From: Thomas Callaway
Sent: 03 February 2015 14:15
To: Planning.Responses
Subject: RE: Planning Consultation on: LU/371/14/PL

Engineers comments in respect to surface water drainage:

APPLICATION LU/371/14/PL

Description of Works: Conversion of shop to flat & erection of 1no. bungalow

FLAT FLOOR ALL AT 1 LEVEL.
 REV A ROOFLIGHT ADDED TO BUNGALOW BEDROOM 16.12.14.
 NOV 2014, DRG 2A

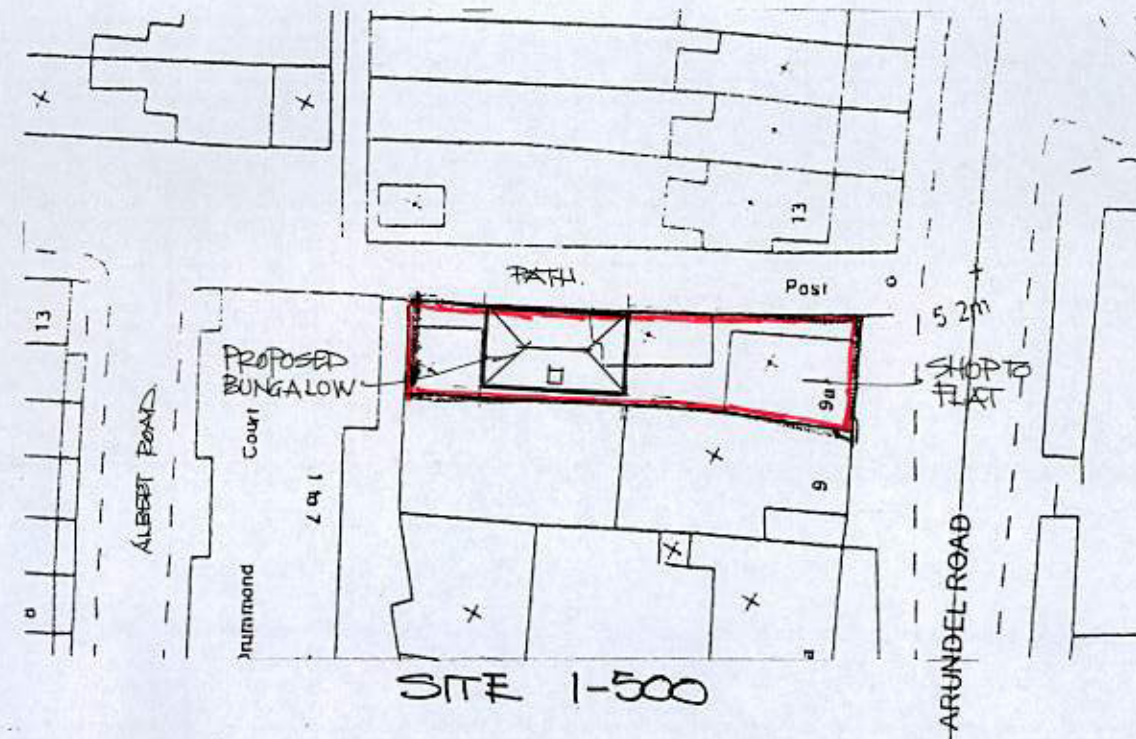
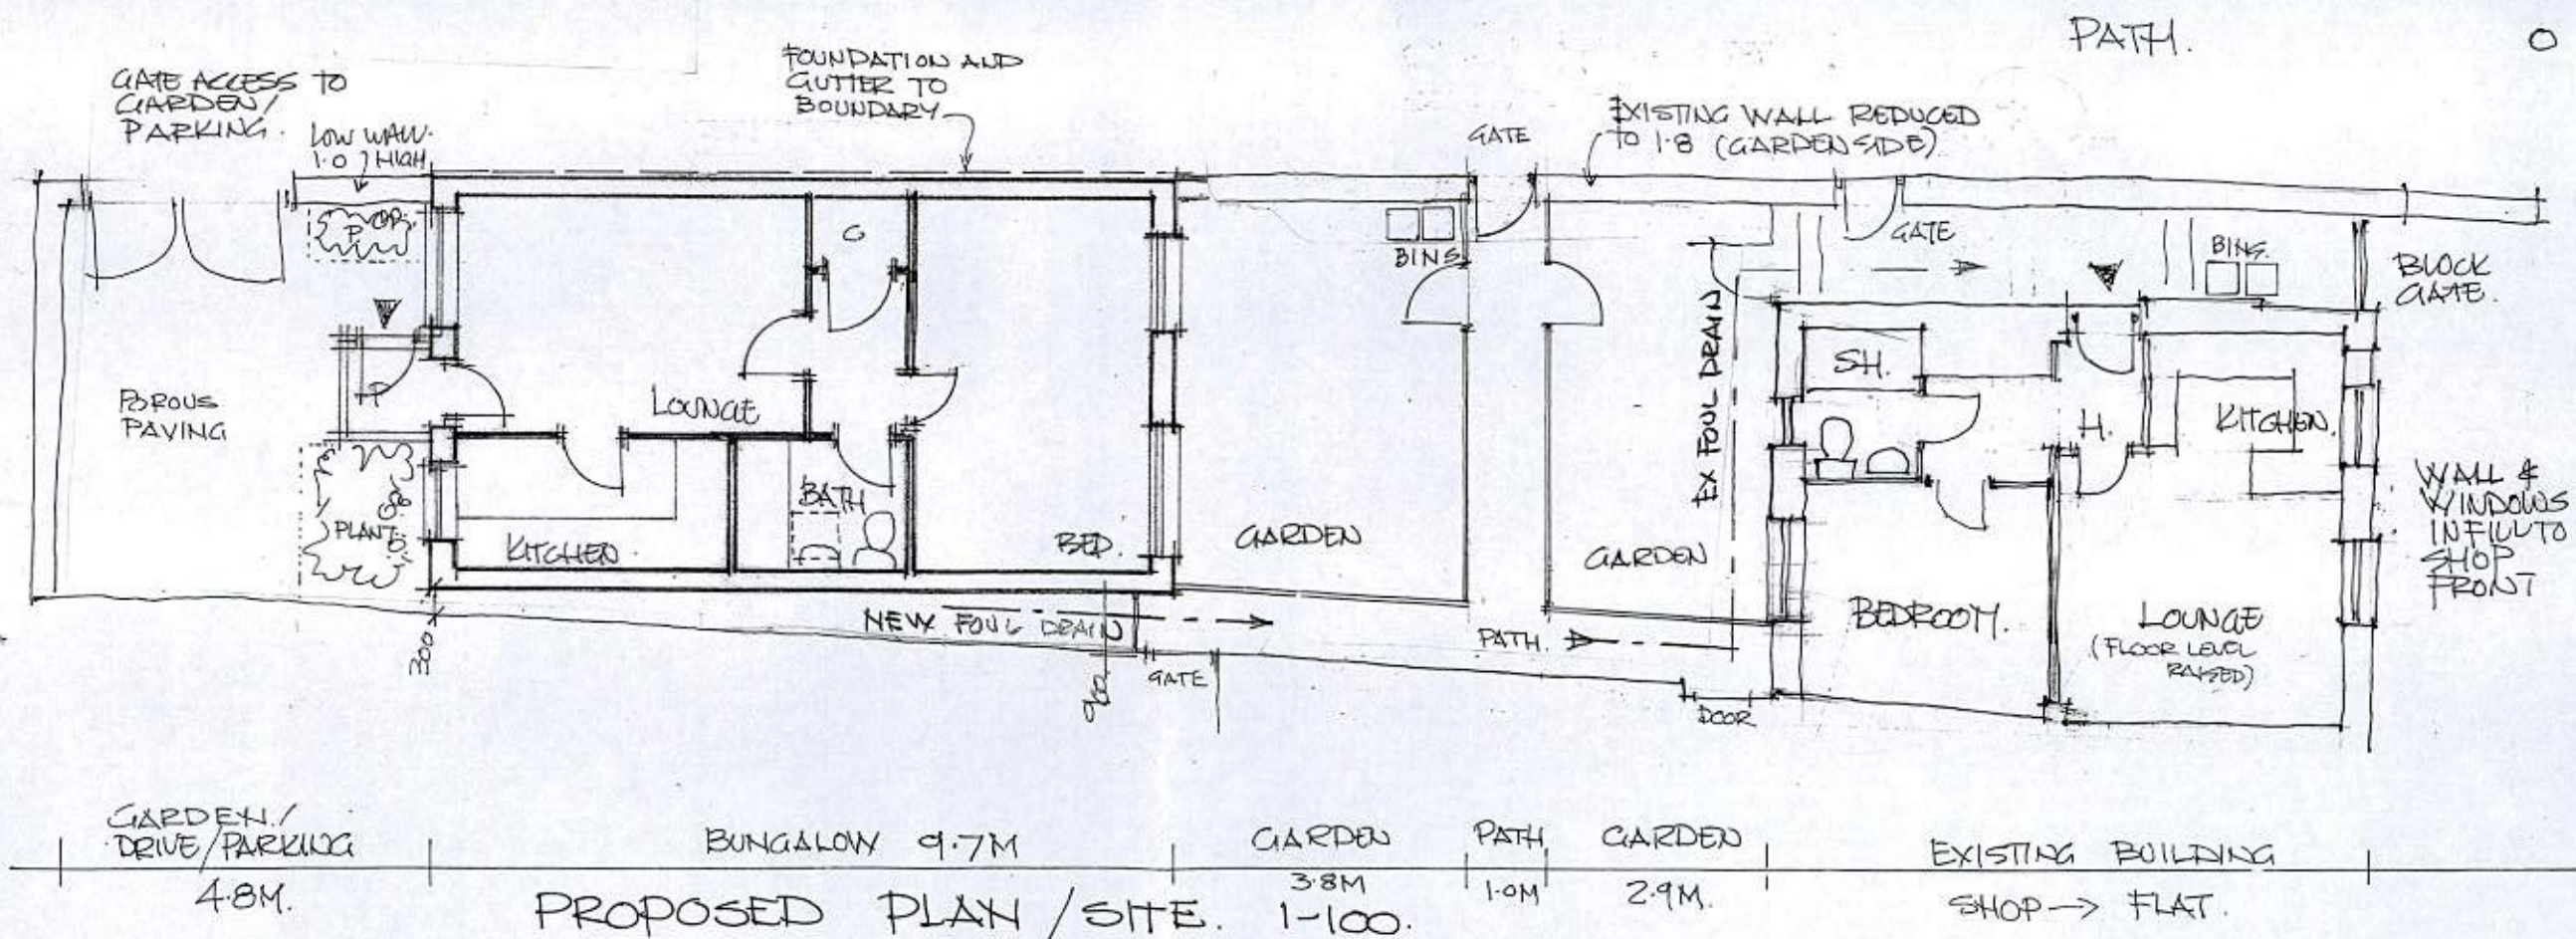
The applicant states that surface water from the new building will be discharged to soakaway and porous driveway.

Please apply standard conditions ENGD2A.

Infiltration rates for soakage structures are to be based on percolation tests undertaken in the winter period and at the location and depth of the proposed structures. The percolation tests must be carried out in accordance with BRE 365, CIRIA R156 or a similar approved method and cater for the 1 in 10 year storm between the invert of the entry pipe to the soakaway, and the base of the structure. It must also have provision to ensure that there is capacity in the system to contain below ground level the 1 in 100 year event plus 30% on stored volumes, as an allowance for climate change. Adequate freeboard must be provided between the base of the soakaway structure and the highest recorded annual groundwater level identified in that location.

Any SuDS or soakaway design must include adequate groundwater monitoring data to determine the highest winter groundwater table in support of the design. The applicant is advised to discuss the extent of groundwater monitoring with the Council's Engineers. Supplementary guidance notes are also enclosed for information.
